Heckington Fen Solar Park

EN010123

Statement of Common Ground with Natural England

Document Reference: 7.6i

| Condense / Sho | ow Columns Cond | ment Idense / Show Rows Instructions | | | | | | | | | | | | | | | | | | | Change in broad | d habitat type dete | cted. Check compliance with guidance. | | | | | | | |

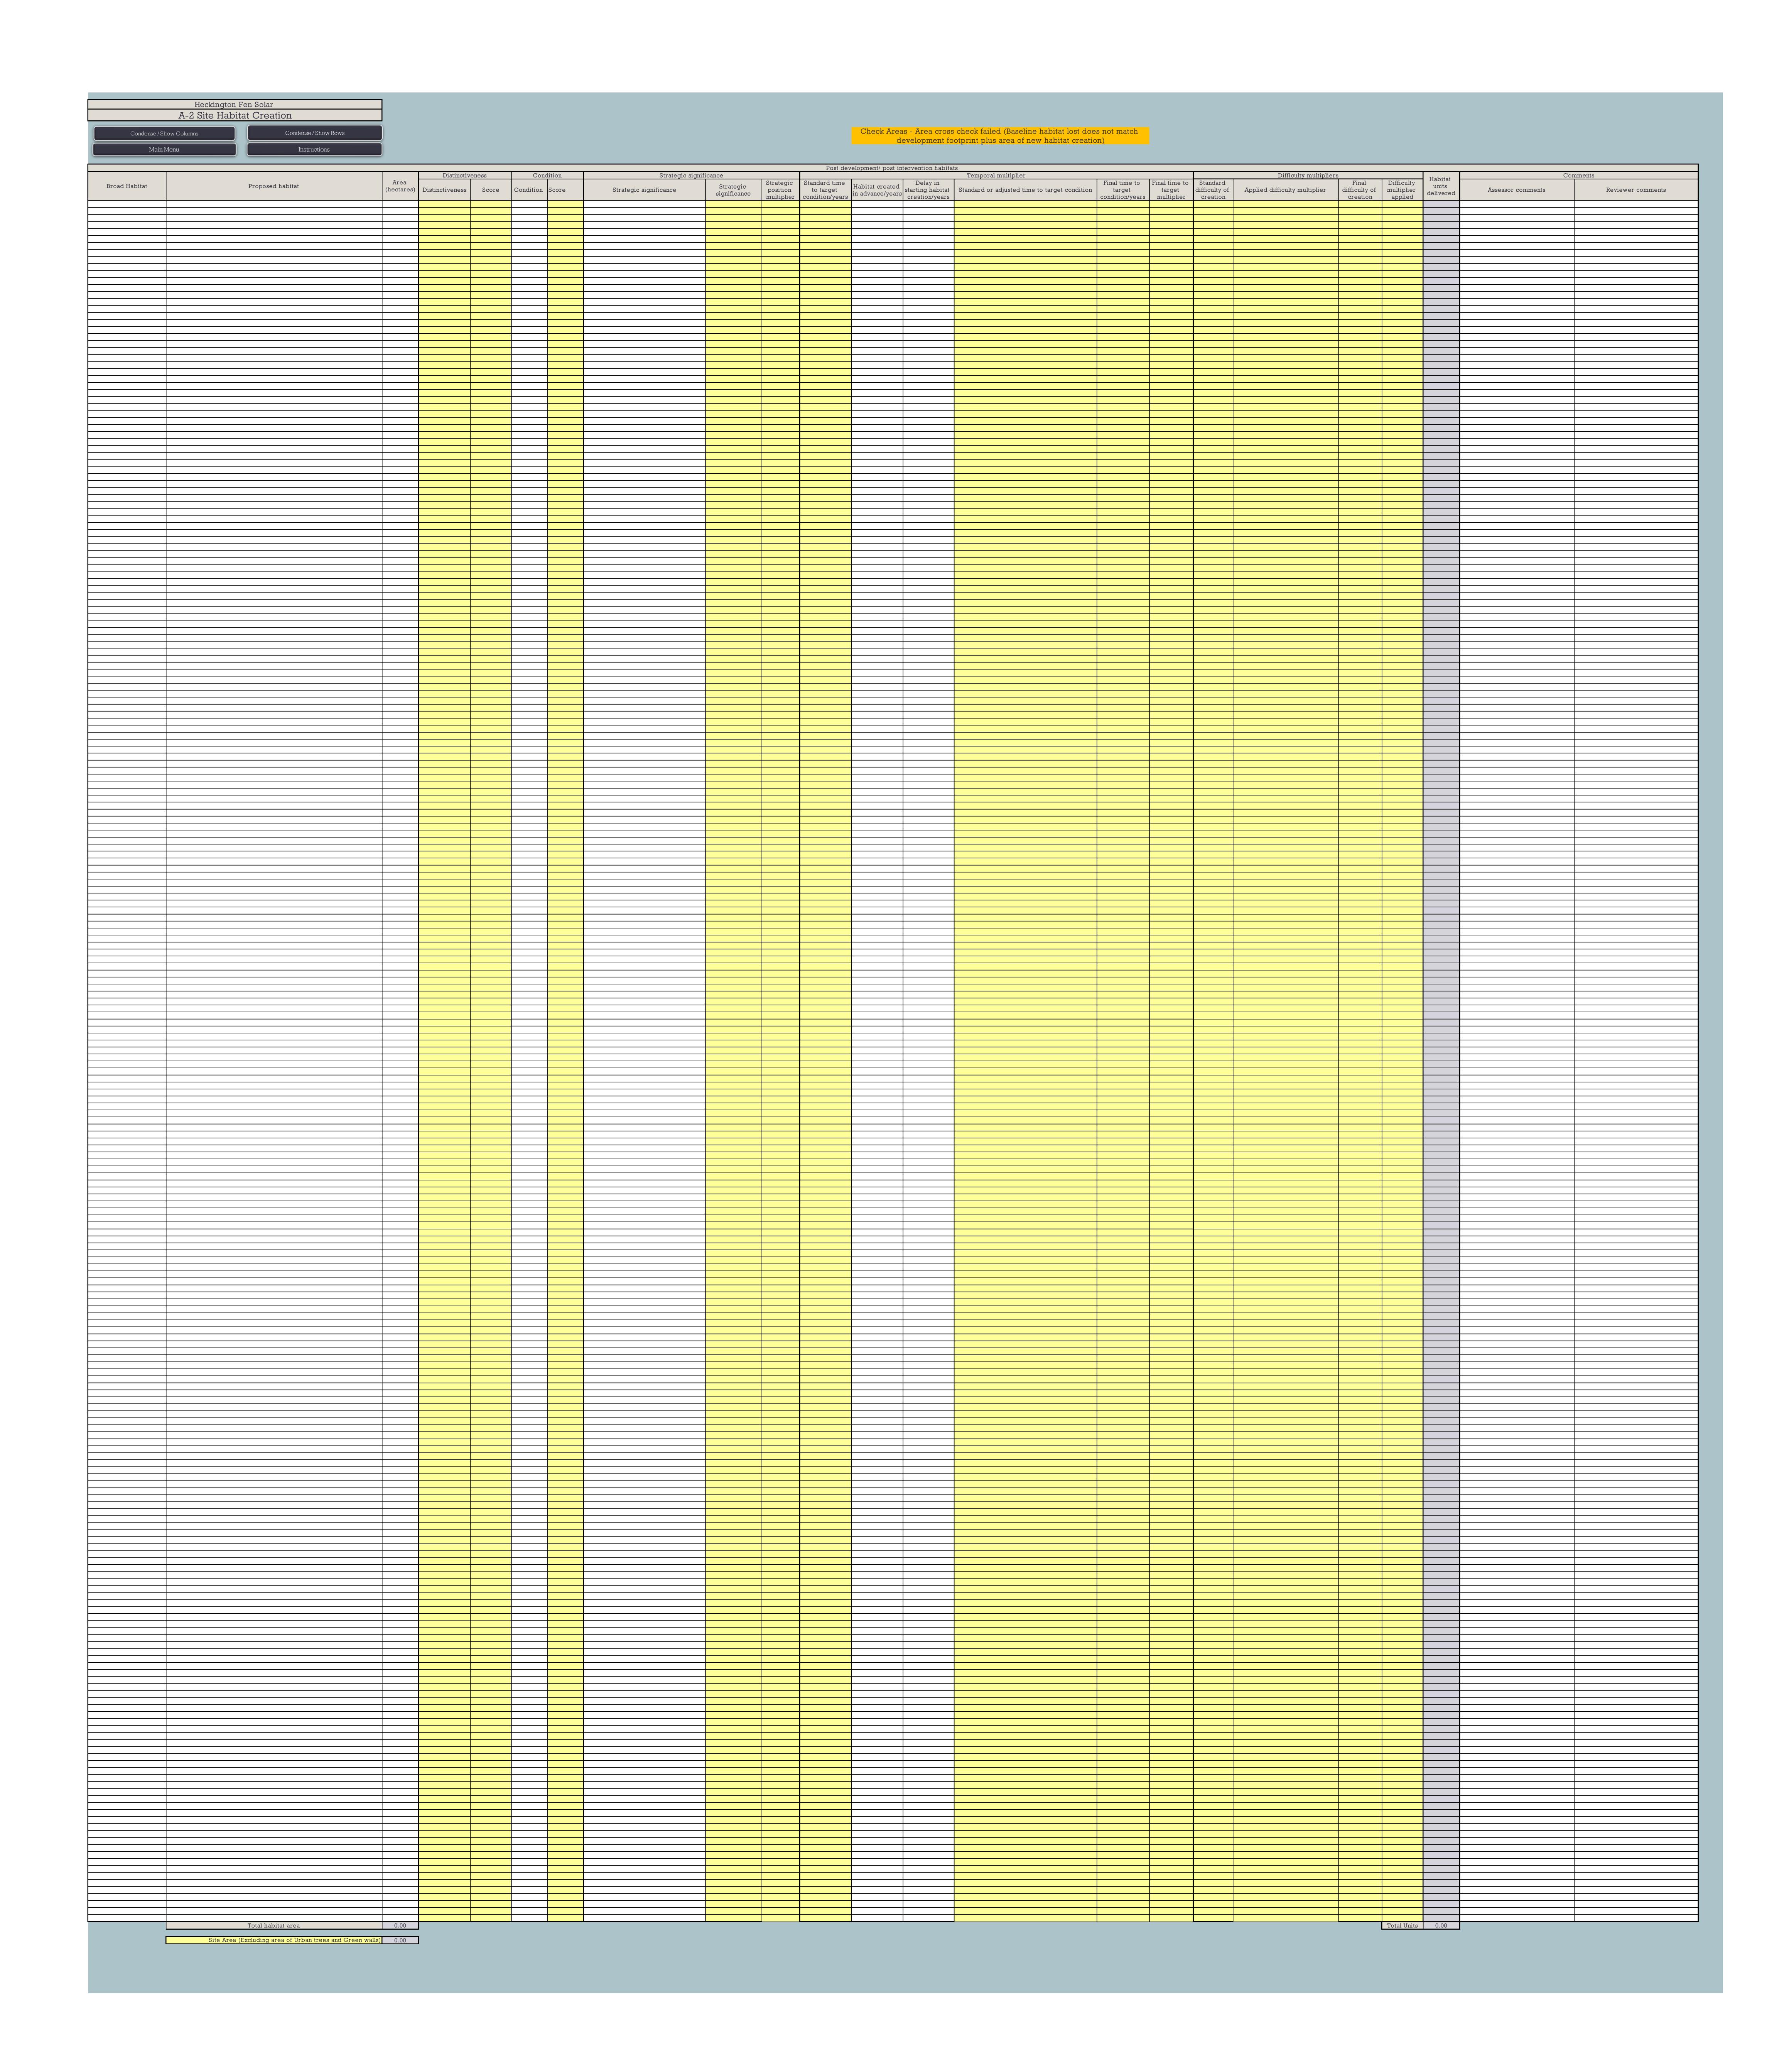
6. Biodiversity Net Gain			
6.1 Agreed	Biodiversity Net Gain Metric 3.1 used (Appendix 8.12) provided to NE on 20 th June 2023.	NE welcomes the commitment to deliver BNG and is generally supportive of the enhancements proposed through the development. The enhancements detailed within the oLEMP, are welcomed and are likely to indirectly have a positive effect.	The Applicant notes NE's comments made in relation to BNG during consultation which are generally supportive of the enhancements proposed, and detailed in the oLEMP.
